Application for a non-material amendment following a grant of planning permission.
Town and Country Planning Act 1990

House:		Suffix:	
House name:	Littlehampton Swimming And Sports Centre		
Street address:	Sea Road		
Town/City:	Littlehampton		
Postcode:	BN16 2NA

Proposed development of new leisure centre facility (Use Class D2) and demolition of existing leisure centre facility and sports dome, including modifications to the existing car parking arrangement, landscaping and associated works.

Revised location for gas meter housing, from original location at the west of the building, to proposed location at the Sea Road boundary.

DESCRIPTION:
SITE PLAN : PROPOSED INCOMING SERVICES

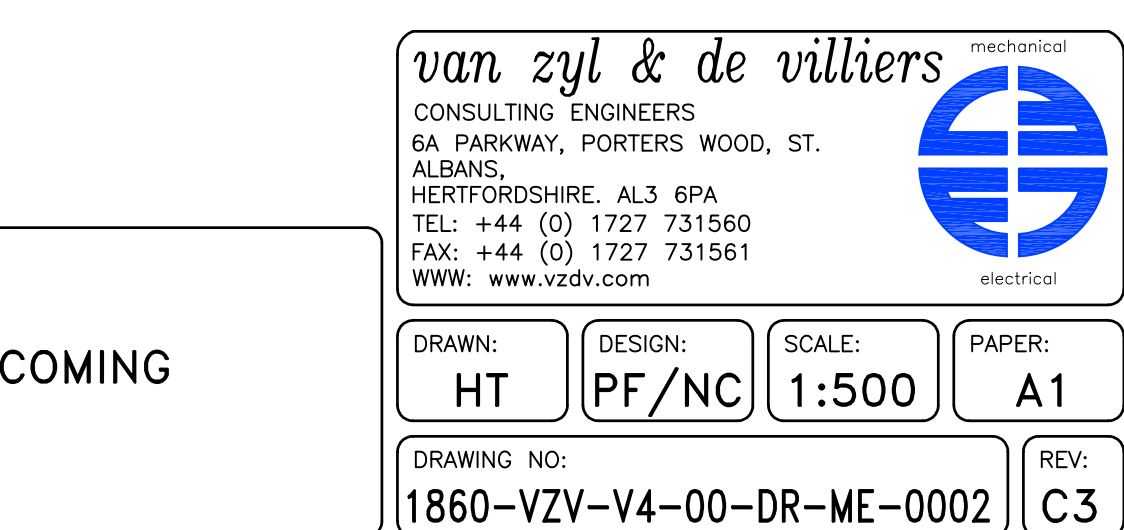
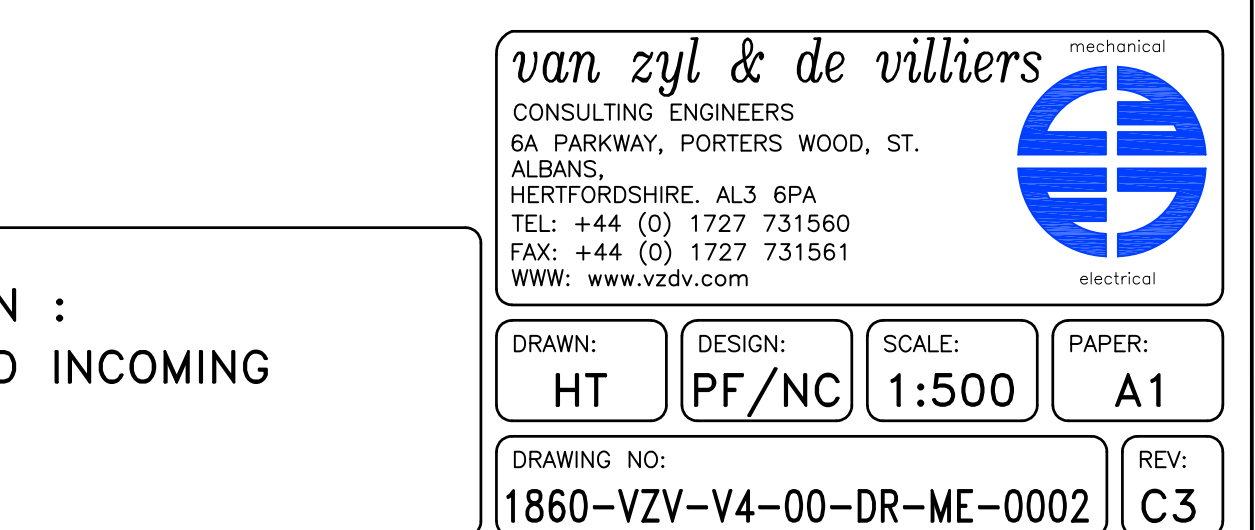
Gas providers Southern Gas Network, when consulted regarding the installation of the gas meter, advised they will require access to the meter from the site boundary, and will not accept the currently permitted location.
